State of Washington
DEPARTMENT OF FISH AND WILDLIFE

SUBJECT: WDFW COMMENTS ON CU-21-00002 SWEETWATER RANCH

Thank you for the opportunity to comment on the CU-21-00002 Sweetwater Ranch application concerning the construction of an event center on Charlton Road near Naneum Creek (“the project”). Washington Department of Fish and Wildlife (WDFW) has reviewed the application and supporting documents. Our comments are regarding the project’s impact on priority fish and wildlife habitats, particularly shrubsteppe and riparian habitats.

REVISED SITE PLAN
DATED 11-16-21

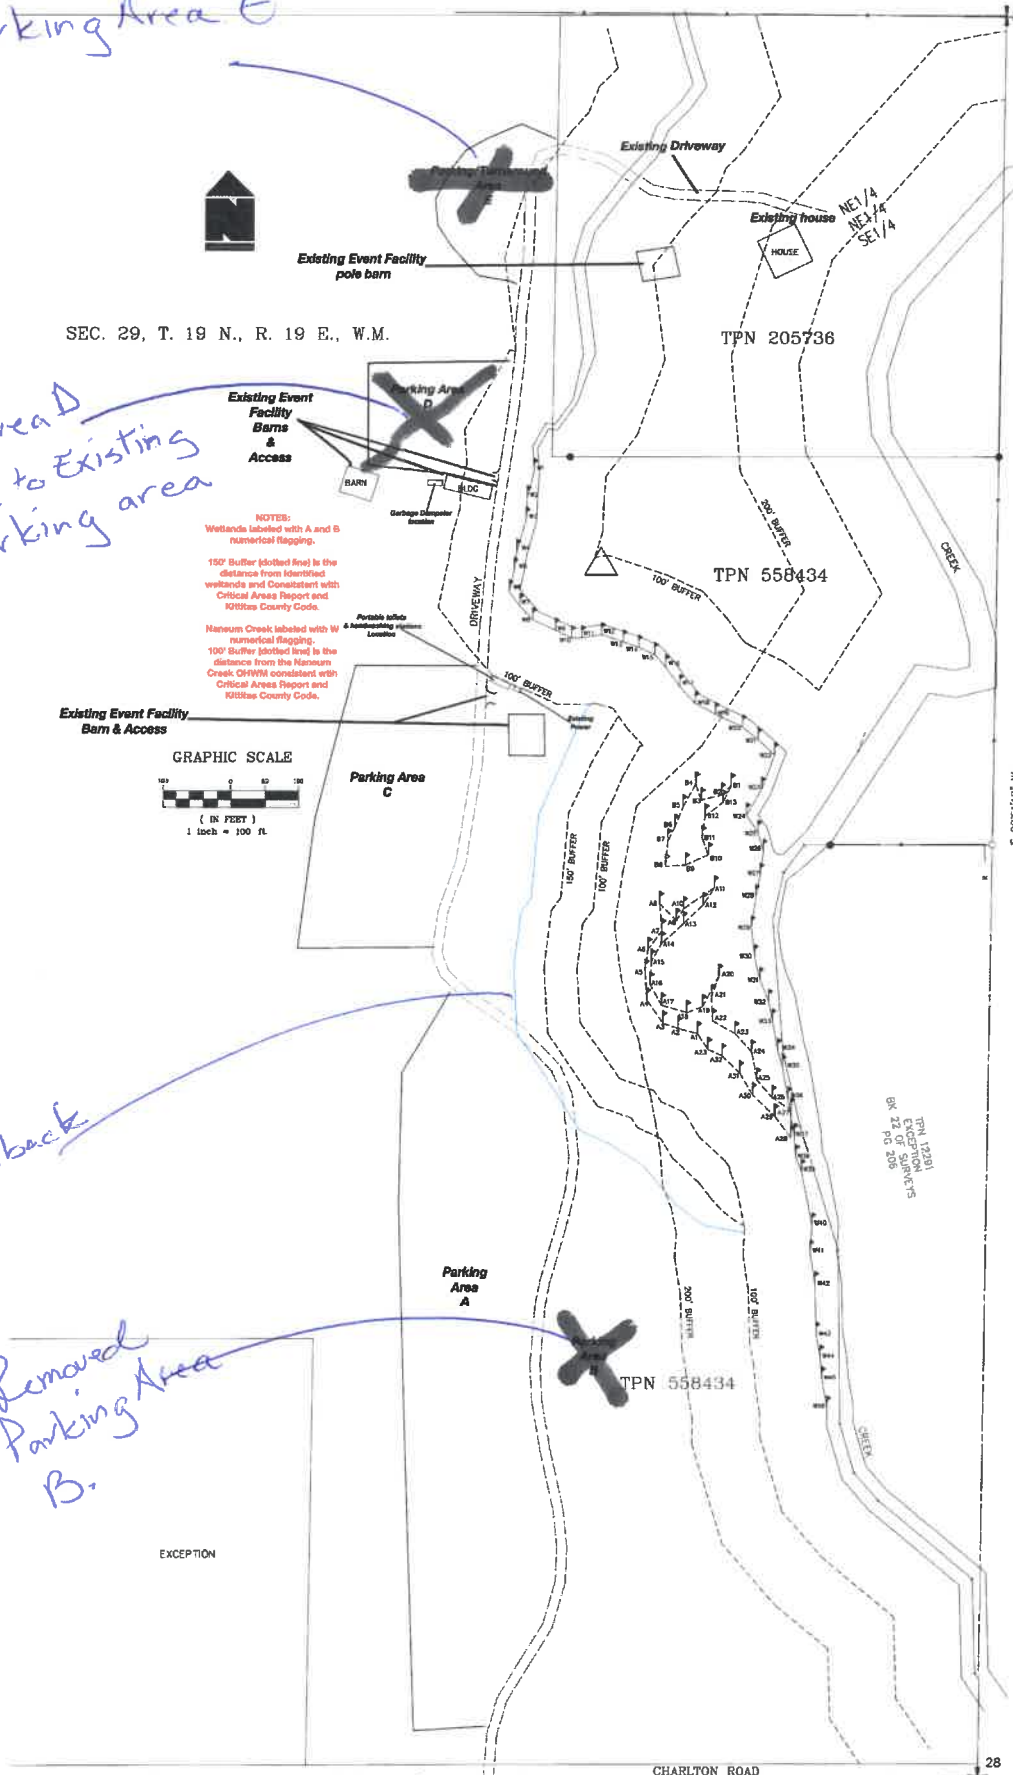
The proposed parking areas, particularly Parking Area D and E (and potentially C depending on the extent) are within priority shrubsteppe habitat and converting these areas to a parking area would result in loss of shrubsteppe habitat through clearing. Further, from aerial imagery there appears to be a drainage with some riparian vegetation going through these proposed parking areas that would be impacted. It is stated in the critical areas report that this is an irrigation ditch, yet no assessment of current habitat quality or function of that area is described. WDFW would like to understand the impacts of that drainage for fish and wildlife habitat. Parking Area B is next to a well vegetated area which the critical areas report identifies as an irrigation ditch. WDFW would like to understand the connection of that ditch to Naneum Creek and the implications of the parking area on the associated habitats here. WDFW requests that these parking areas either be configured to avoid these habitat impacts, or habitat mitigation proposed (such as enhancement of other habitat areas on the property)
